Application for a non-material amendment following a grant of planning permission.

Proposed rear dormer window over existing outrigger, raising the height of existing rear chimney stack; front boundary treatment and associated hard landscaping to front garden area of dwellinghouse

Reference number:	<input type="text" value="21/1284"/>
Date of decision	<input type="text" value="18/06/2021"/>

PROPOSED ROOF PLAN
SCALE: 1:100

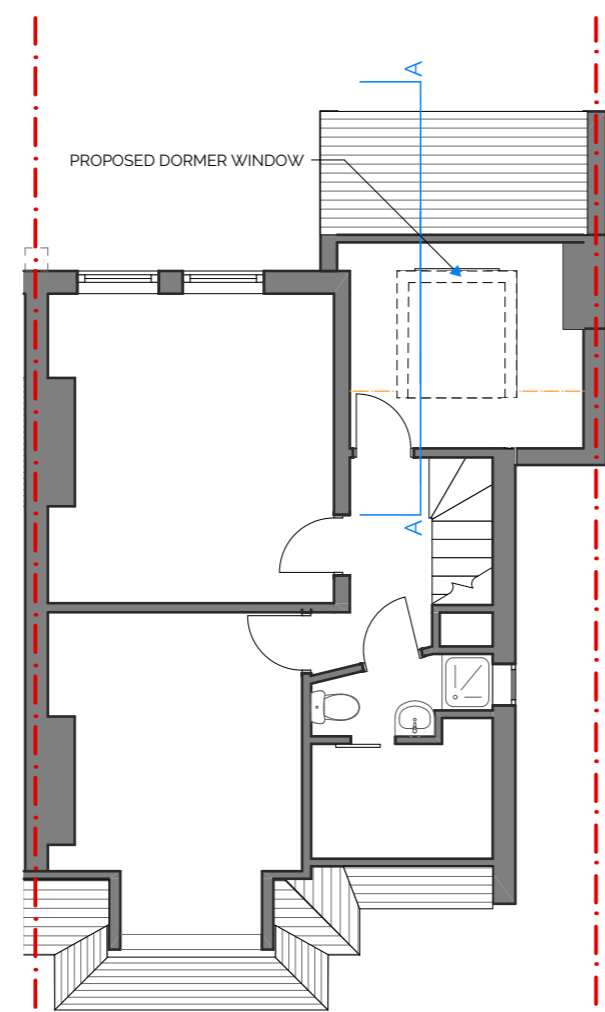
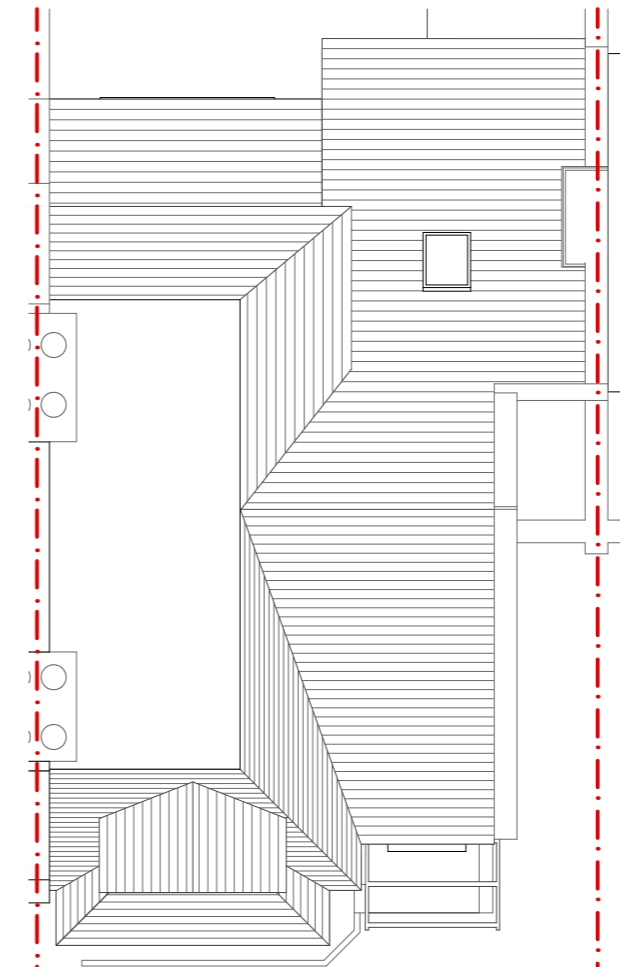
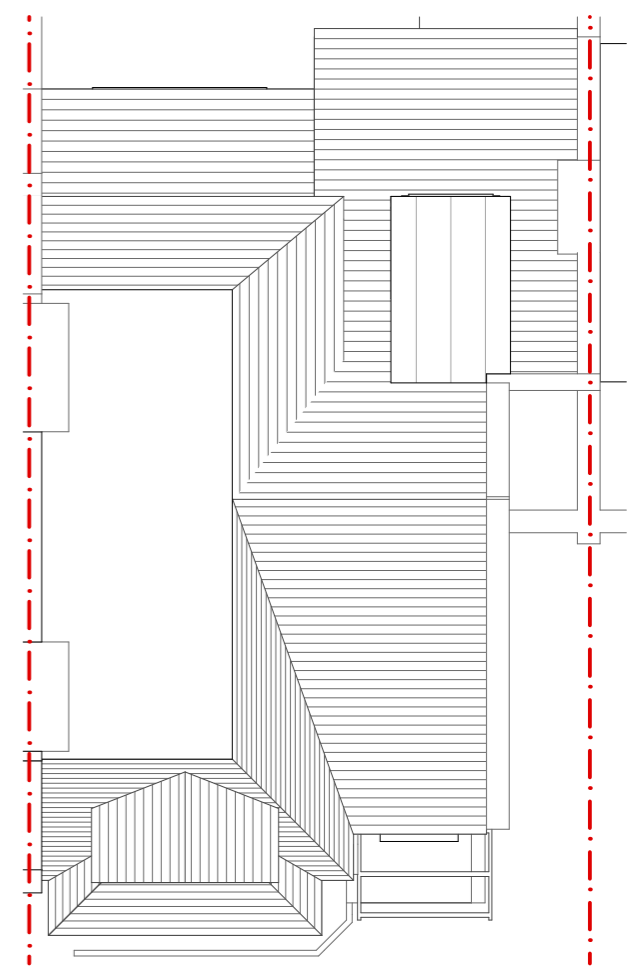
Reduce dormer window width from full width across the roof to half of its width.
Change wall finish from zinc to vertical tiling.
No alternation to the chimney stack
